Board Order
ABP-312523-22

Planning Register Reference Number: P/DC/3/25/21

WHEREAS a question has arisen as to whether drawing number DoE2 (elevations/fenestration patten) is materially consistent with the granted planning under planning register reference numbers 13/94 and 18/178 at 63 Threadneedle Road, Salthill, Galway is or is not development or is or is not exempted development:

NOW THEREFORE An Bord Pleanála, in exercise of the powers conferred on it by Section 5 (3)(a) of the Planning and Development Act, 2000, as amended, hereby decides that changes made to the fenestration of the house during the course of construction at 63 Threadneedle Road, Salthill, Galway is development and is not exempted development.

East Elevation - Rear Garden - Declaration of Exemption 2021
1:100

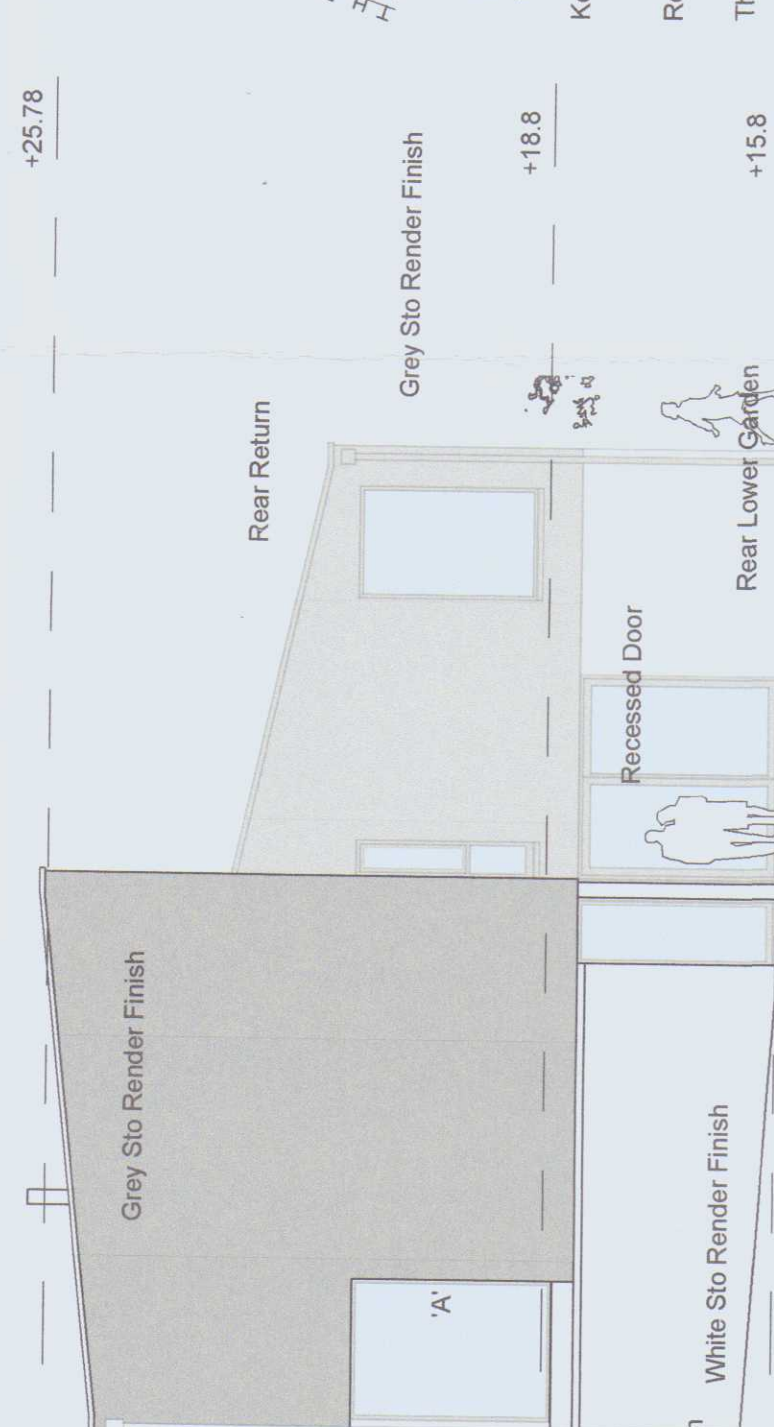
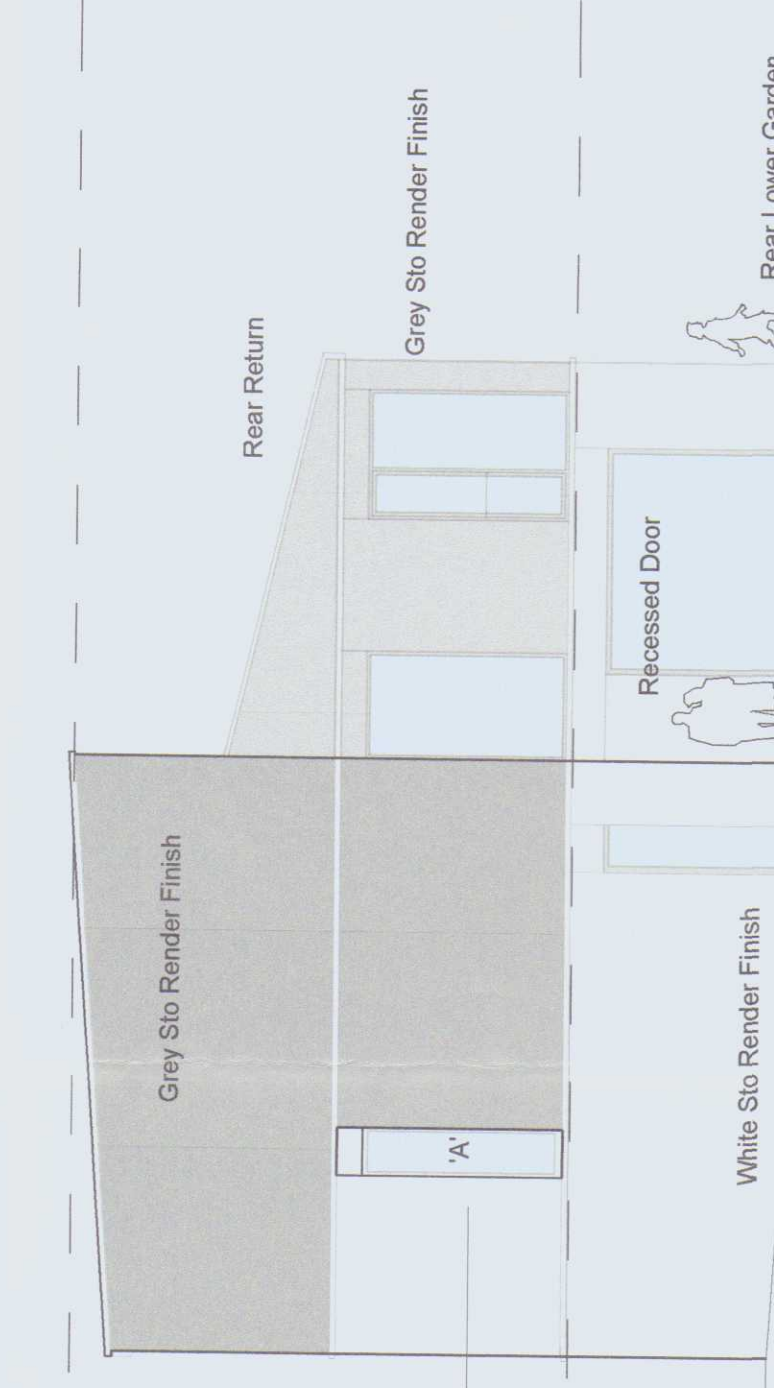
- (b) the development carried out differs from that for which planning permission was granted under planning reference 13/94, as extended under planning reference 18/178, and the Board is satisfied that the deviations from the permitted development are significant and material, and are not immaterial or de minimis, and are not, therefore, within the scope of the development granted planning permission,
